Horse Shelter Location update

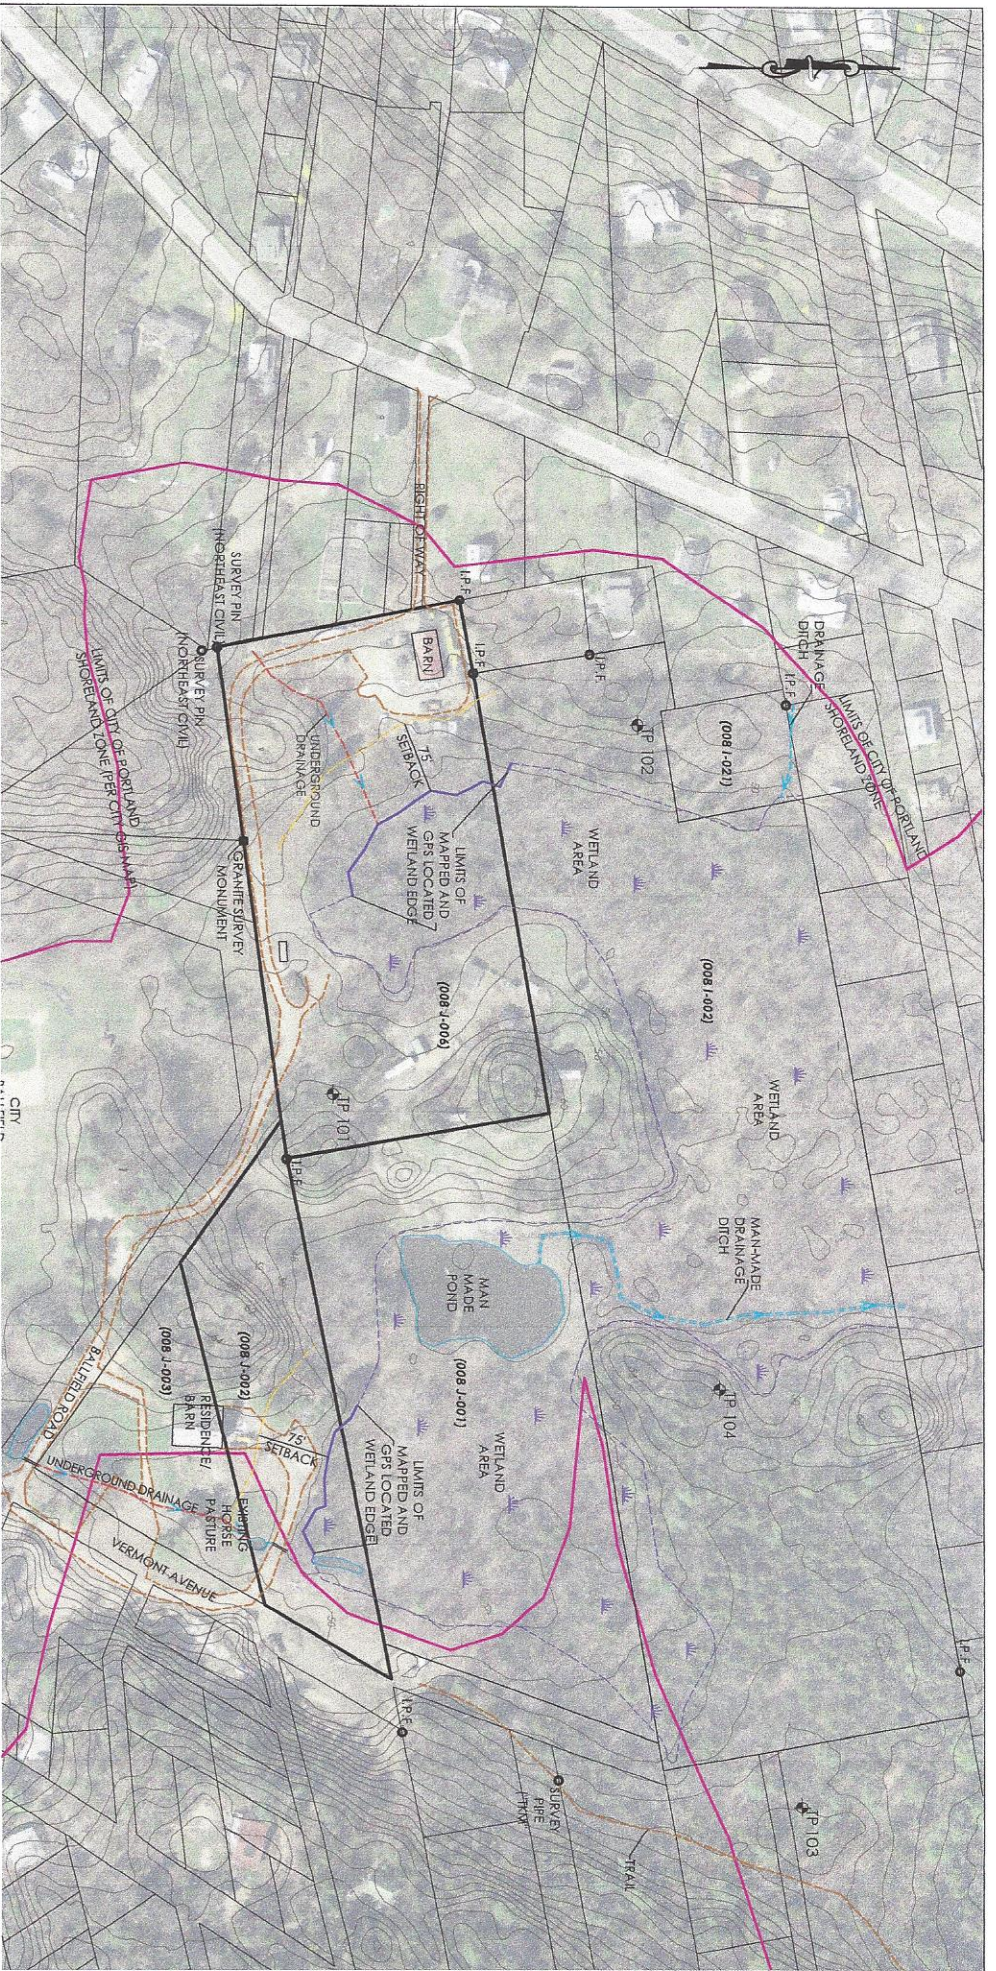
I am OK with the wetland setback now. However, when I scale from the green line to the edge of the Vermont Ave right-of-way, it only scales to about 50 feet. Have you measured it on the ground and found it to meet the 100 foot setback requirement?

Please note the comment about the tax line map being too far westerly from the pins. I believe the line is much closer to the edge of Vermont Ave. Yes there is room to make the 100' set back from the line between the pins, somewhat easterly from what the tax map shows. The circular area I indicated is significantly larger than the 12x24 moveable shelter.
